Wenona School, Project Archimedes

Attachment A - Response to Submissions

Plate 1: Ground Floor Apartment 11: View south across courtyard space

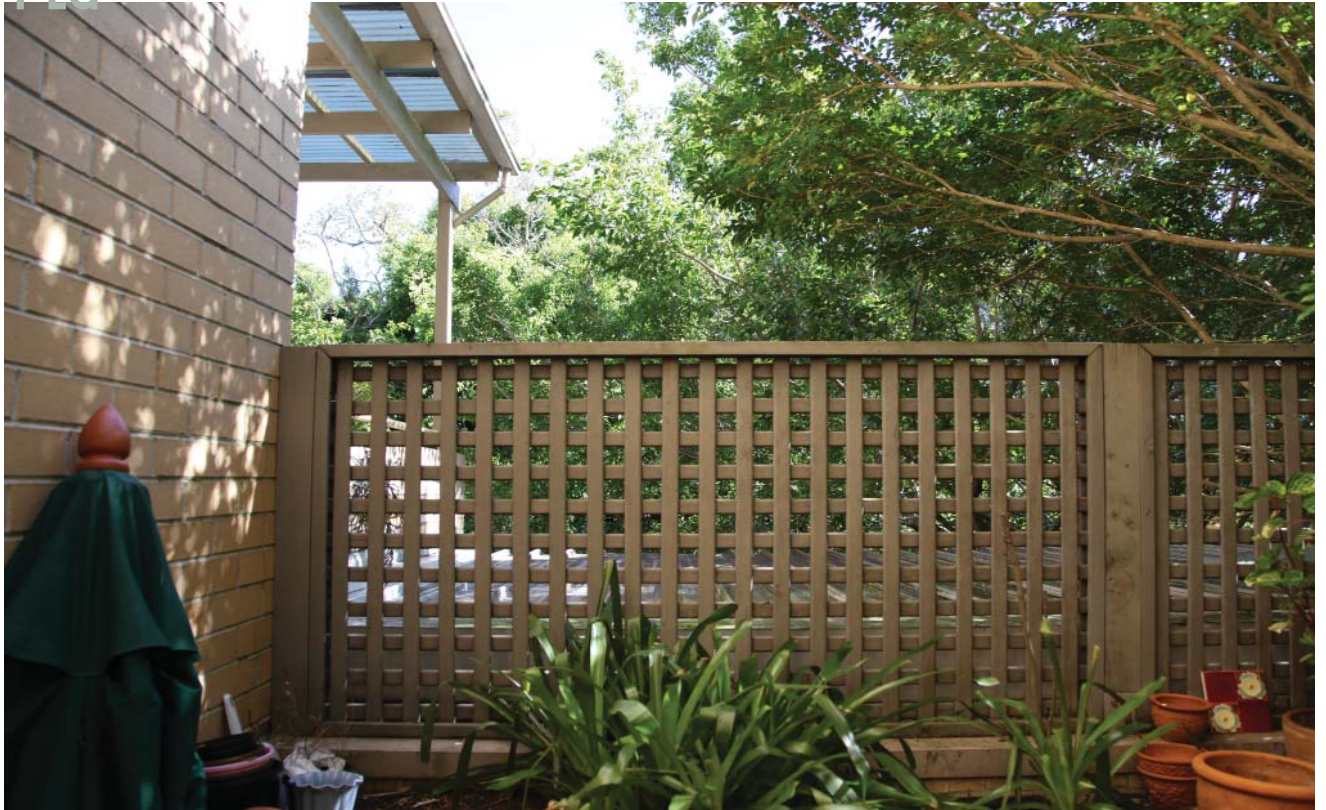
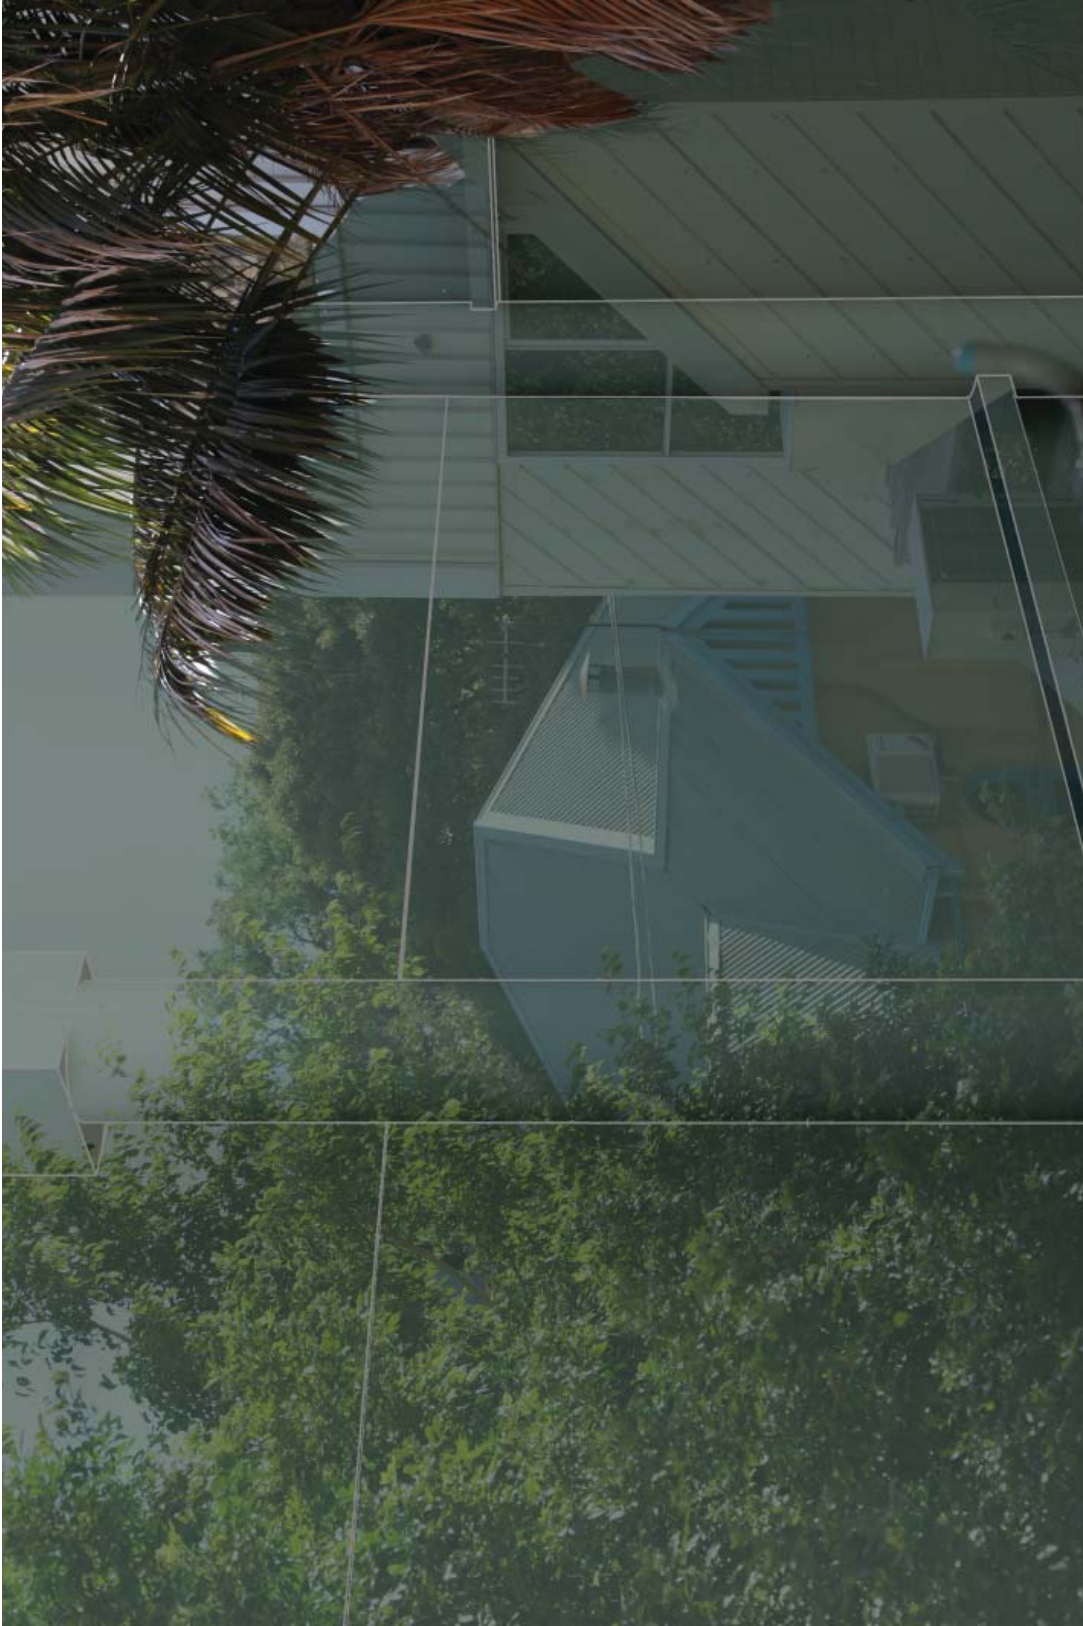
At 267 Miller Street the terraces (recorded as such on the strata plan, and not as 'courtyards') are on individual unit titles and are not common property, that living rooms and bedrooms of units 1 and 12 face the property boundary across their private terraces, that main bedrooms of the corner 'ground' / 'bottom' floor units, 2 and 11, look - and open, significantly via a sliding door - on to their respective private terraces adjacent to the narrow strip of common property planter boxes along the building's boundary, and that 'ground' / 'bottom' floor units 1, 2, and 12 do not have access to either a terrace or balcony area elsewhere.	Noted.
The setback extends only part of the way along the property boundary with 267 Miller Street's recessed private residential terrace, balcony, and window area.	Refer to response above.
Beyond the eastern alignment of the balcony zone where the wall of the proposed new building is not set back and is instead at the property boundary with the private terrace of unit 12 and that of unit 11, the separation of the facades will be just over 5 metres and then about 6 metres. Significantly, in the south eastern corner the proposed wall will be just over one metre from the window of the sliding door to the	Refer to response above.

ELEVATION 267 MILLER STREET WITH OUTLINE OF PROJECT ARCHIMEDES

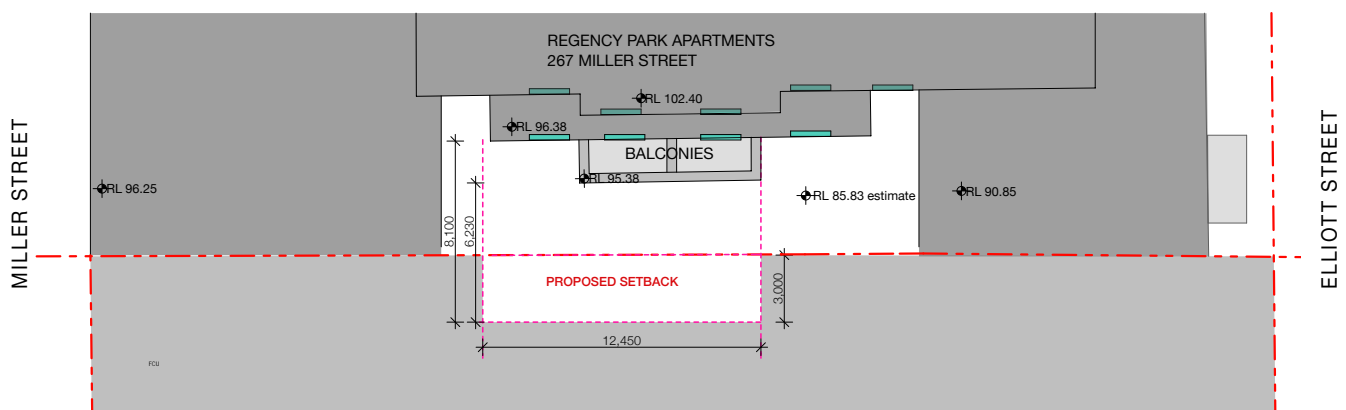
Issues Raised by Agencies	Action
To understand the existing built form, the north elevation plans are to be amended to incorporate the existing building outline of 265 Miller Street.	A revised North Elevation, including an outline of 265 Miller Street, is provided at Attachment B .
Details of the proposed fritted glazing treatment to the lightwell to mitigate visual amenity impacts to the adjoining residents is to be provided for assessment.	<p>Wenona appreciates the need to prevent any adverse visual impacts on adjoining residents, as well as the need to maintain privacy for occupants of the proposed building. However, the design intent is for staff, students and visitors to still have a 'sense of the outdoors' and so the material still needs to have an element of opacity to enable light transmission.</p> <p>Whilst the materiality of the light well has not yet been resolved, TZG has provided indicative images of the proposed glazing finish (refer to Attachment B). It is anticipated that the transparency of the glass may be lessened in areas where there is no direct line of site between the neighbouring and proposed buildings. Where there is a direct interface, it is anticipated that frosted or opaque glass, with a decorative frit / pattern will be used to establish a more 'solid' appearance to prevent any visual connection between the two buildings.</p>
